14208
19 June 2014

**SECTION 75W MODIFICATION MP11_0082
3 MURRAY ROSE AVENUE, SYDNEY OLYMPIC PARK**

This modification application seeks to amend Project Application MP11_0082 by modifying the wording of Condition B4 within the Instrument of Approval. Condition B4 relates to 'Access for People with Disabilities'.

Drawing Title
THE CHASE -
DETAIL PLAN

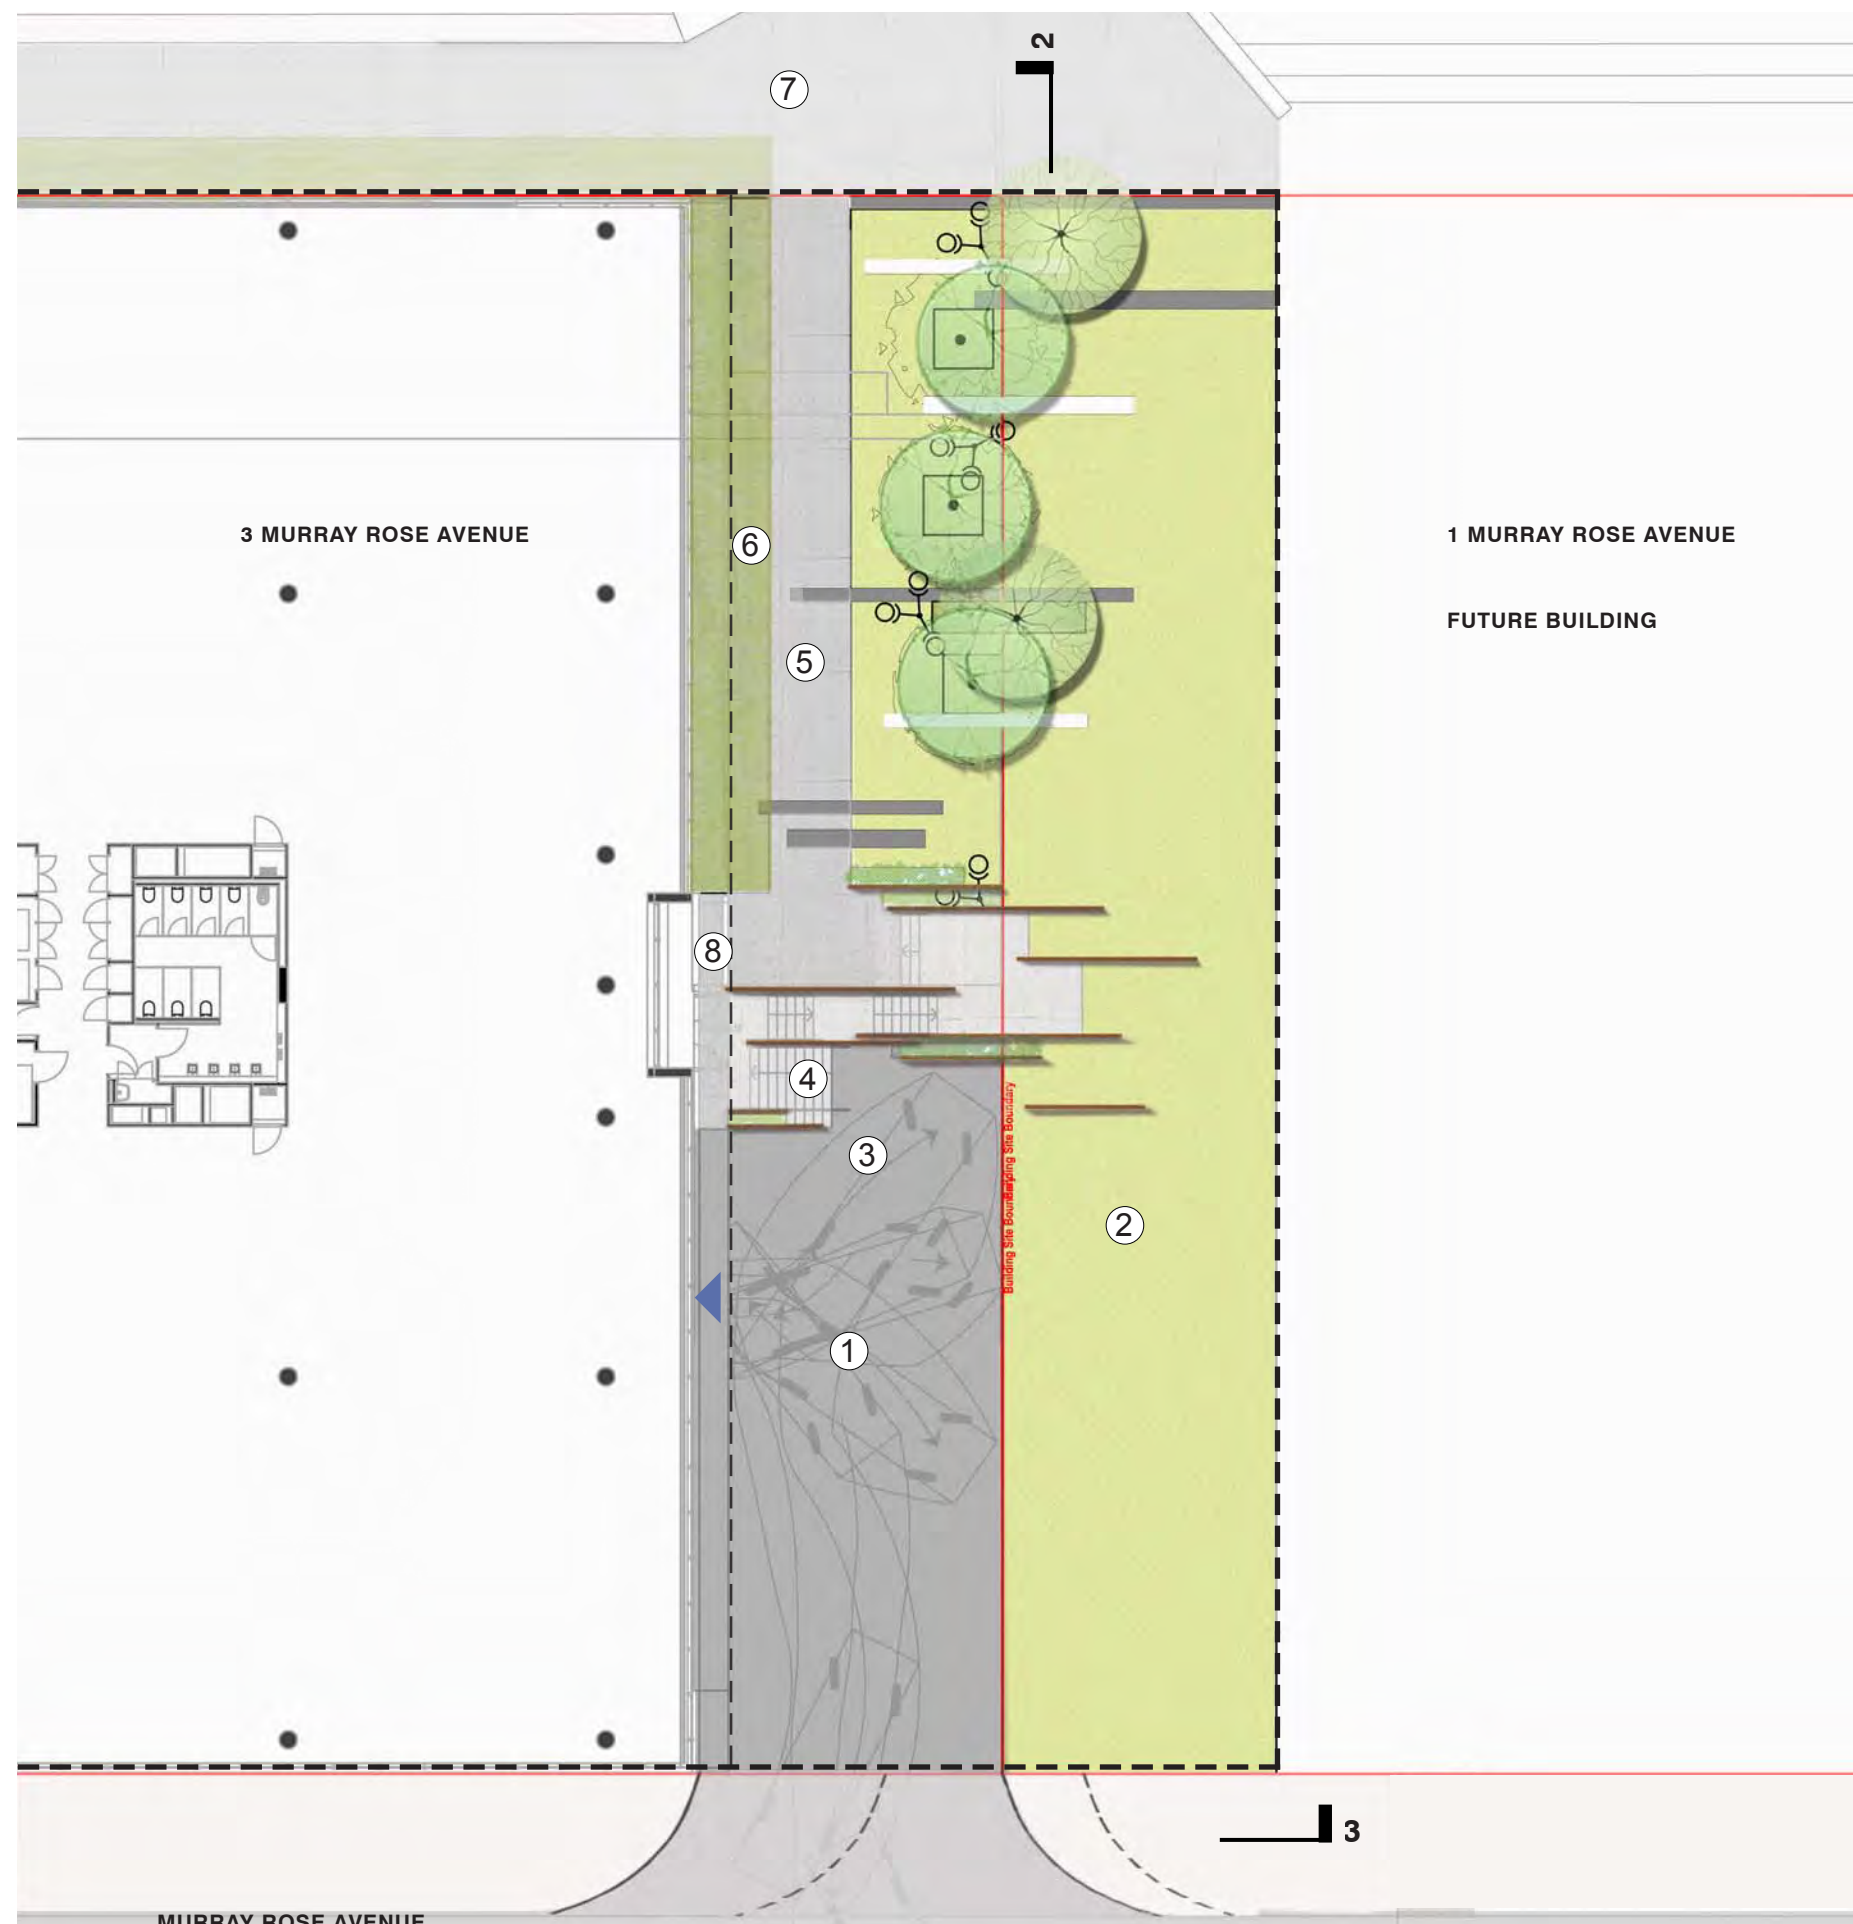
The development of the Chase as approved on the stamped plans would require a significant re-design of the stairs in order to comply with Condition B4 as currently worded. Accordingly, it is considered that the Guidelines should not be implemented as mandatory rules and the wording changes proposed reflect this.

"the pedestrian path within The Chase is shown as 1.2m wide and not consistent with the Authority's Access Guidelines which nominate 1.8m as the minimum width for publicly accessible paths."

Within the Response to Submissions document (dated 28 March 2011), GPT RE Limited confirmed that the path width would be amended within the Chase. As demonstrated in **Attachment 1**, the proposed path width above and below the stairs is a minimum of 1.8m wide and the Chase complies with AS 1428.1 – 2001 – 'Design for access and mobility', as confirmed by Morris Goding in its statement at **Attachment 2**.

It is not envisaged that people will enter 3 Murray Rose Avenue from the Chase, only an emergency fire exit is proposed, as illustrated in **Figure 2** below. The Chase is also not envisaged as a 'principal footpath' which would cater for a large number of people, given it is partly a loading dock. Therefore, it is considered that access can be provided from Murray Rose Avenue to Brick Pit Park for people with a disability without them needing to use the Chase.

- B4. The building and landscaping, ~~including paths within “the Chase”~~, must be designed and constructed **generally** to provide access and facilities for people with a disability in accordance with the Building Code of Australia and SOPA Access Guidelines 2011. ***Compliance with the SOPA Access Guidelines is not applicable to “the Chase” portion of the site.***
